# CITY OF ALBUQUERQUE

June 8, 2015

**Re: NPDES Issues at Beehive Homes  
NPDES Tracking Number NMR12AH78**

ENGINEER'S SEAL	BEEHIVE HOMES	DRAWN BY WCUJ
DAVID SOULE NEW MEXICO REGISTERED PROFESSIONAL ENGINEER 14522	GRADING AND DRAINAGE PLAN	DATE 10-02-13
	Rio Grande Engineering 1606 CENTRAL AVENUE SUITE 201 ALBUQUERQUE, NM 87106 (505) 872-0999	21227-AYOUT-7-13-12
		SHEET # 1
		JOB # 21227

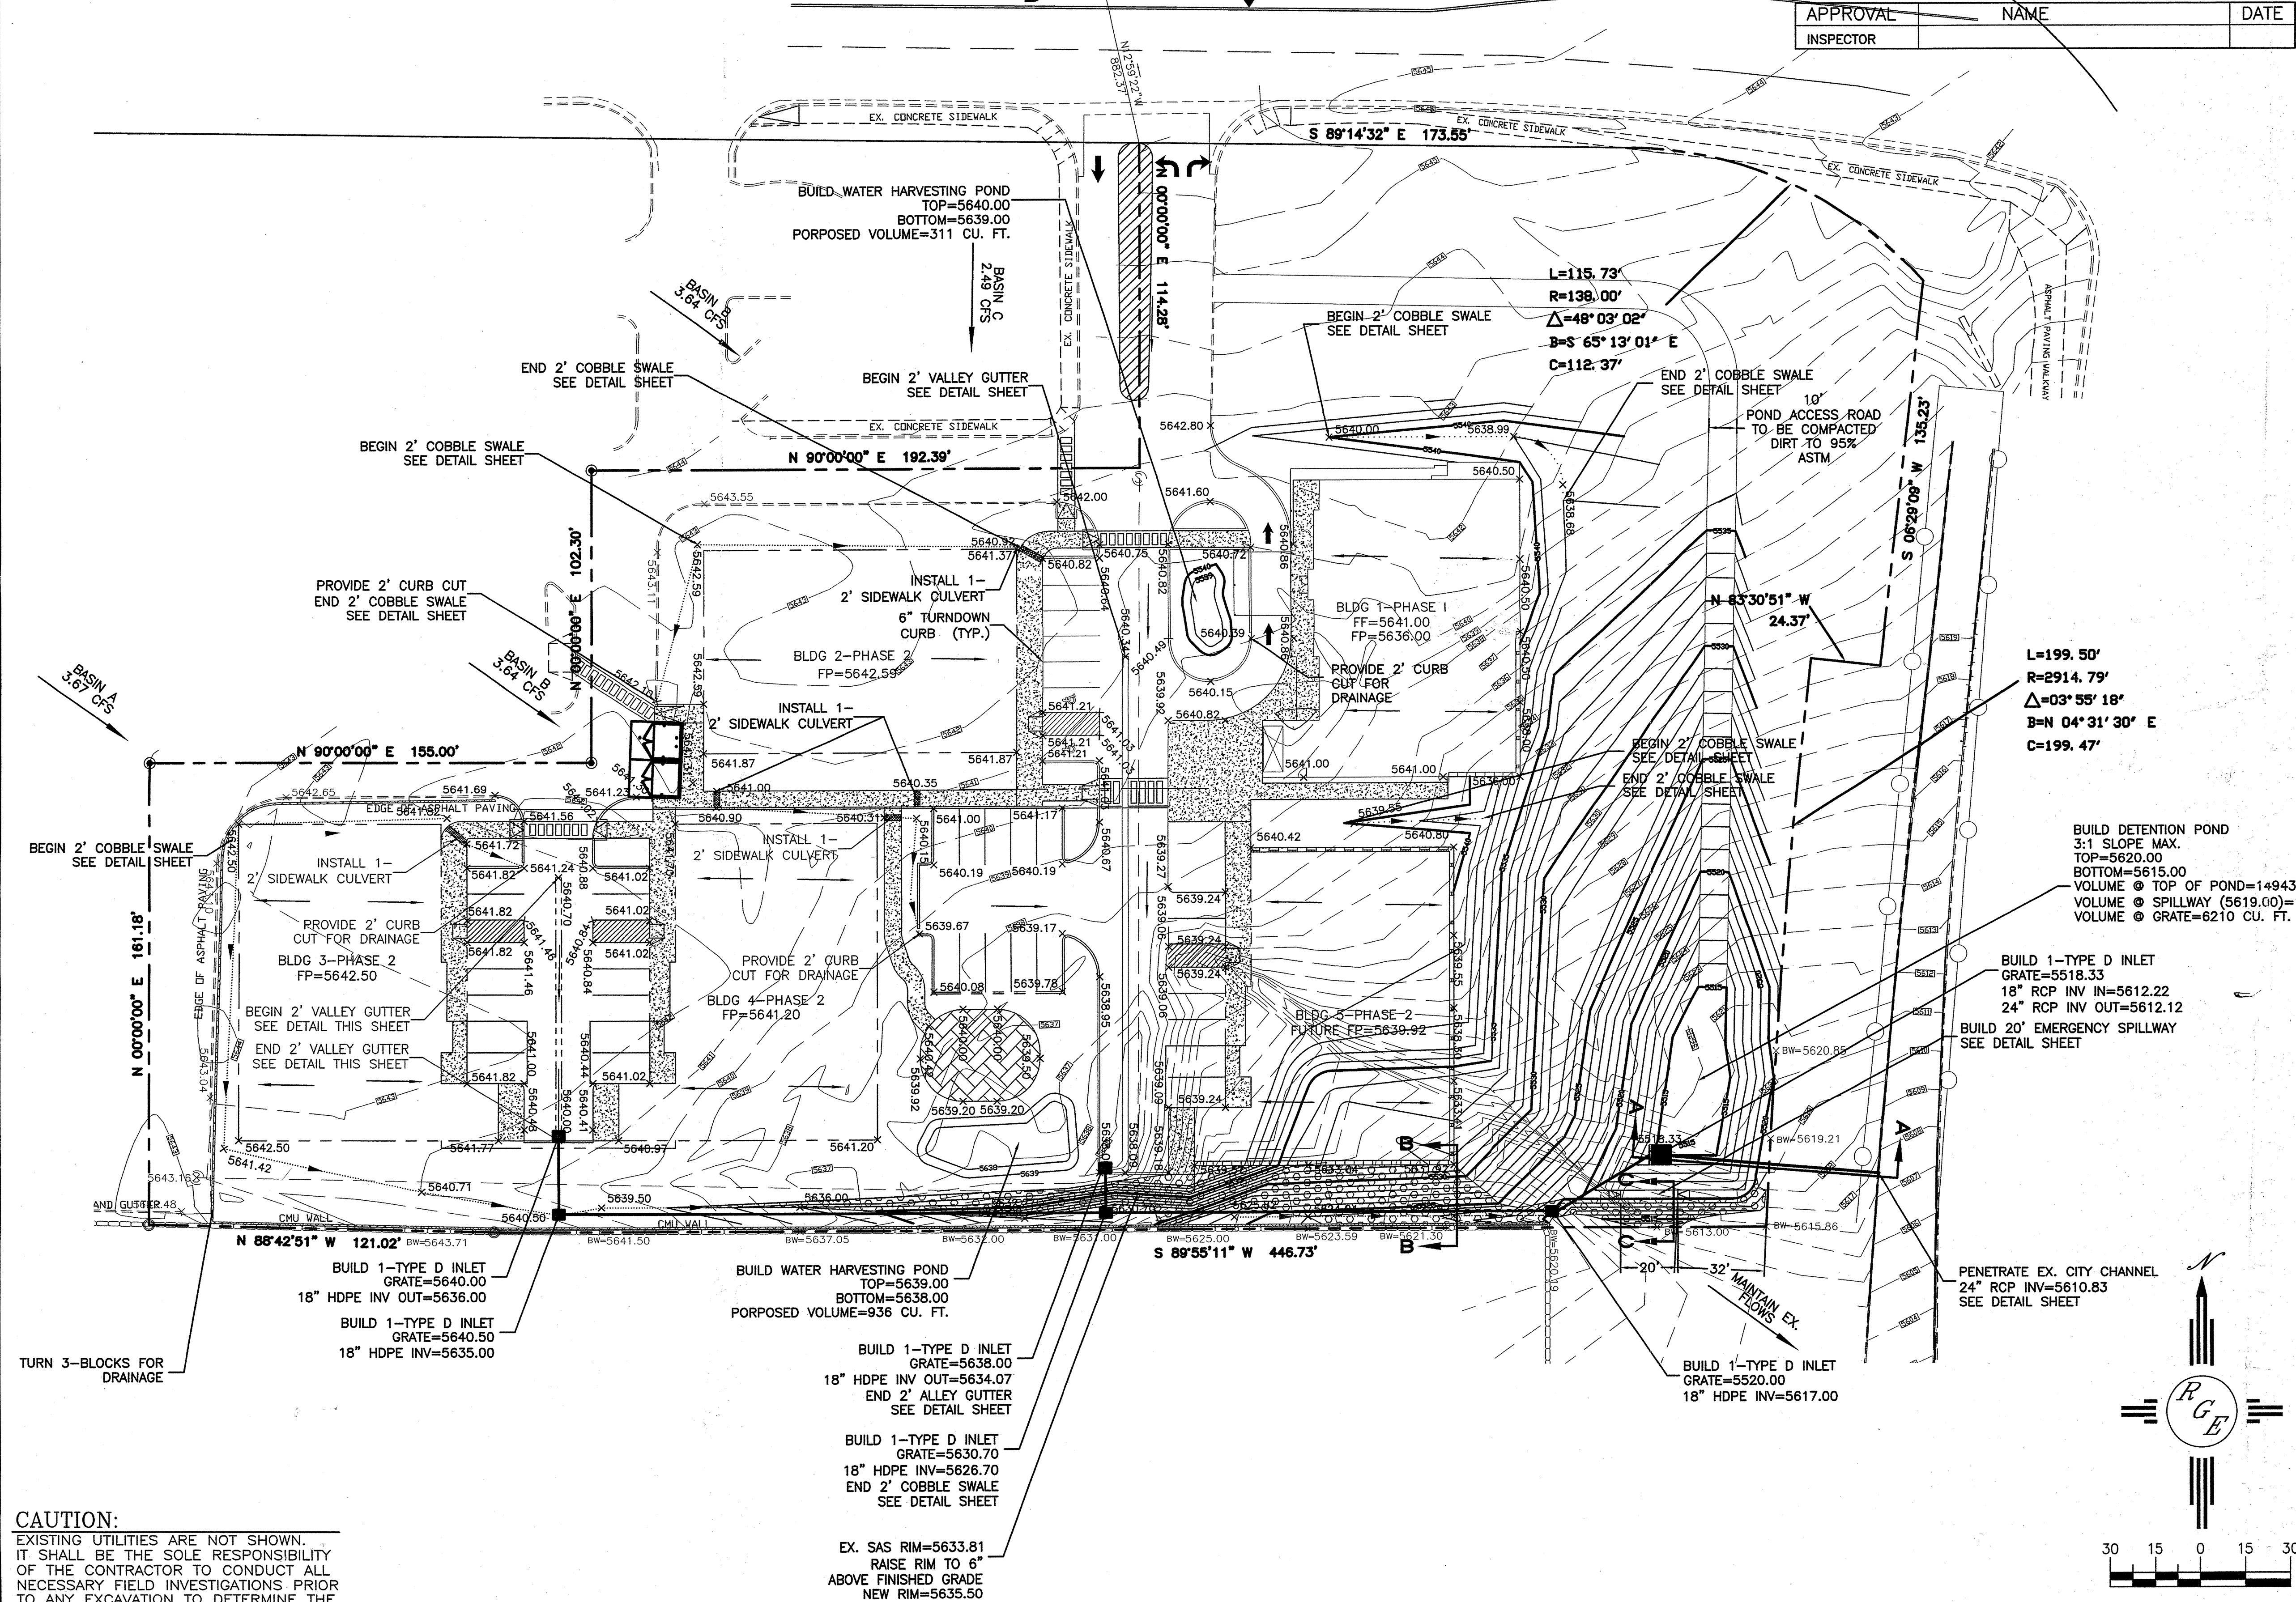
1. There is more erosion on the steep slope and more sediment deposition in the channel than on the previous site visit. See accompanying document.
2. The dirt ramp was still there.
3. Grading did not occur to prevent the steep slope from eroding.
4. A waddle was placed at the inlet at the downstream end of the channel. It appears to be functioning well.
5. The area east of building is eroding. The section that drains to the pond should be mitigated so that the pond does not fill-up with sediment.
6. The area east of the pond is draining south into the City lot and is then contributing to sediment entering the 4-hills channel. The City recommends contacting your Civil Engineer to improve the grading design of this area and the area east of the building.

7. The construction entrance to the north on the west side is full of sediment and should be replaced.
8. Since the construction entrance is not functioning properly, there is track-out to the north.
9. The silt fence is down or torn in several locations. It should be mended or replaced.

The erosion of the steep slope, sediment in the channel along the southern edge of the site, the silt fence maintenance and the construction entrance should be mitigated within seven days.

The erosion of the east portion of the site may take more time as may involve a new design from the Civil Engineer. However, some progress should be communicated to the City within two weeks.
